Project:	Park Danforth
Location:	Portland, ME
Becker Job No:	3422

OBSERVATION REPORT

Cast in Place Concrete

Date:	11-17-15
Time:	8:00 AM
Temp:	34° F
Weather:	Sunny/Clear

**TYP CONTROL JOINT IN WALL**  
N.T.S.

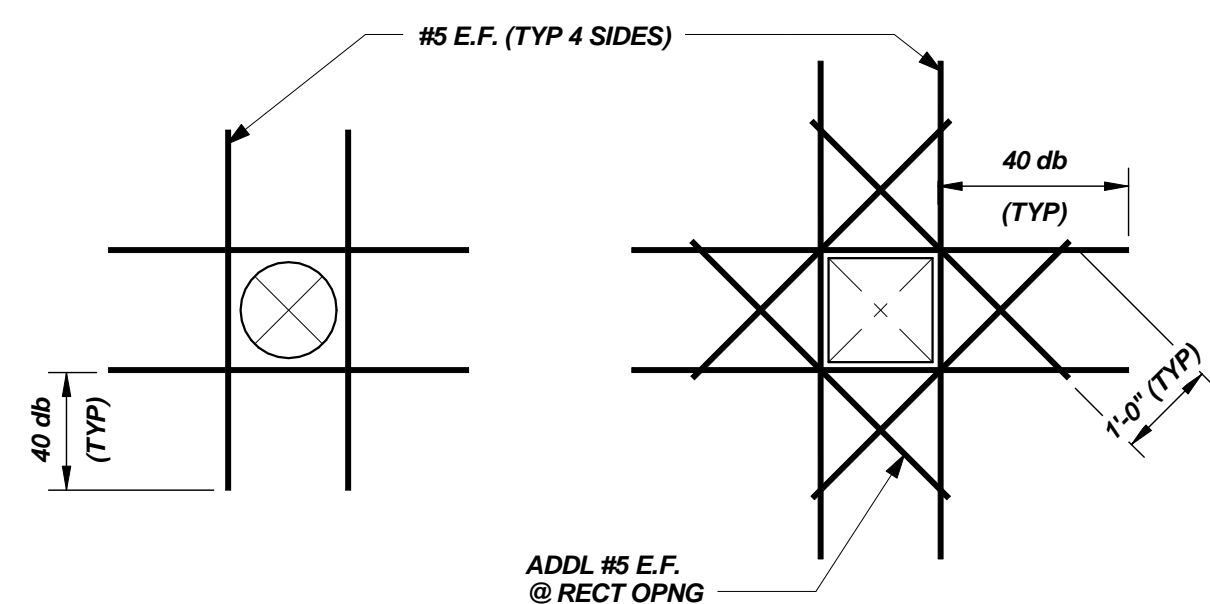
I spoke with Kemp from PC regarding recently returned contraction joint layout per submittal 03 30 00-006 stating "Provide wall contraction (control) joints per typical detail S2.1 between wall construction joints per spacing criteria listed in concrete note 13, S0.0 (40' max or 15' from corner)."

**TYP BEAM POCKET DETAIL**  
N.T.S.

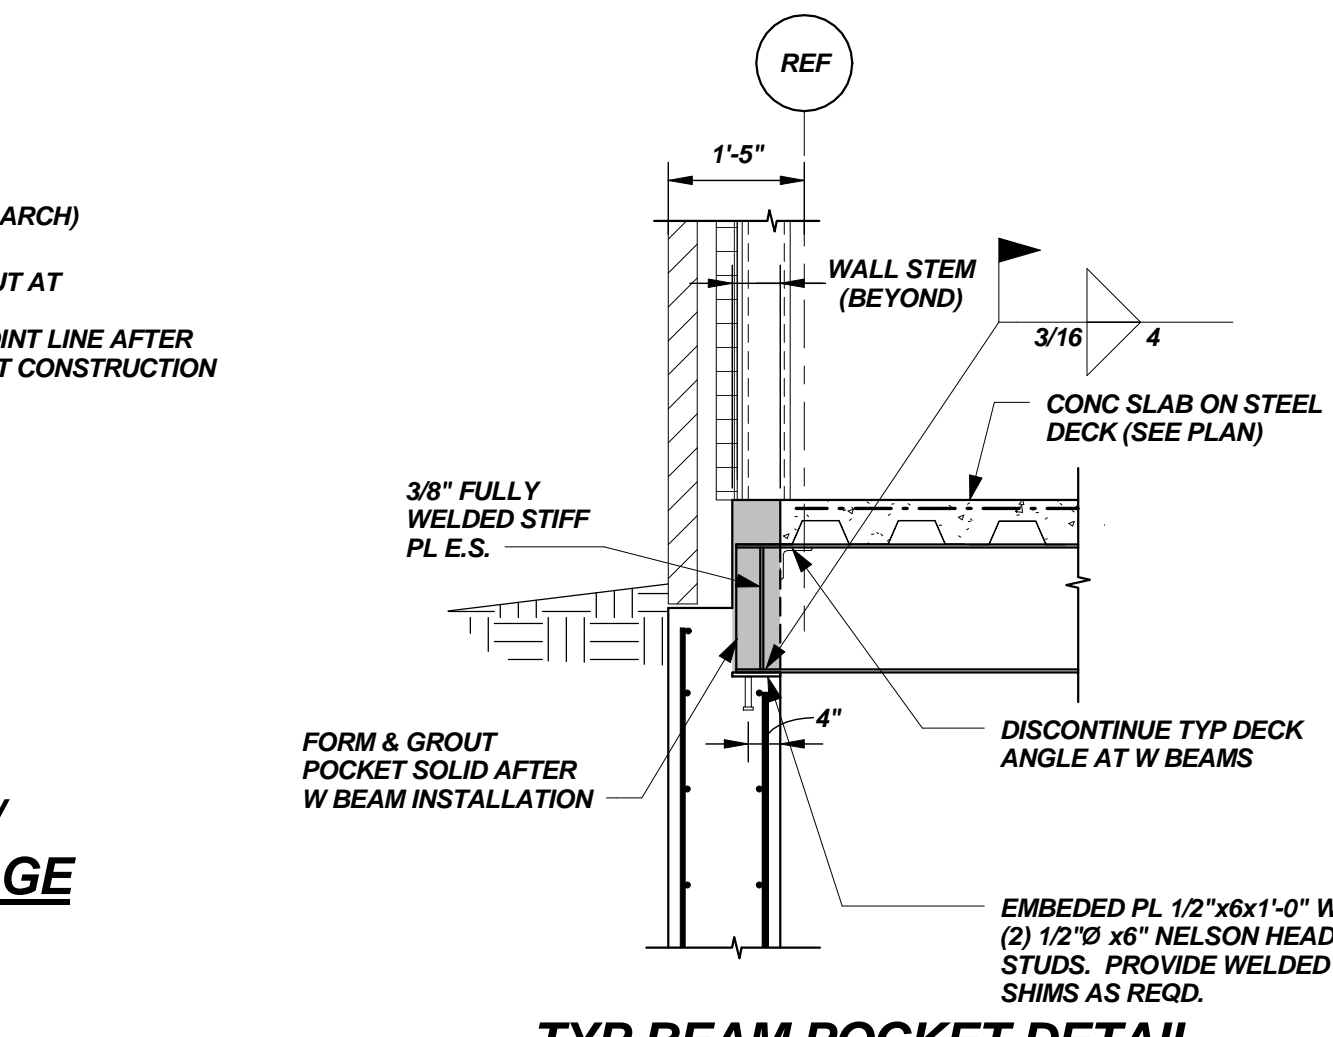
GC note the bearing plate elevations of the beams over the garage entry that pocket into walls G and F are shown at the wrong elevation on the A.B. submittal (off 1"). Additionally the wall height of G and F is at the wrong elevation (off 1"). Convey this information to Giles before wall erection. See section 7/S3.3, section 8/S2.2 and attached for clarification.
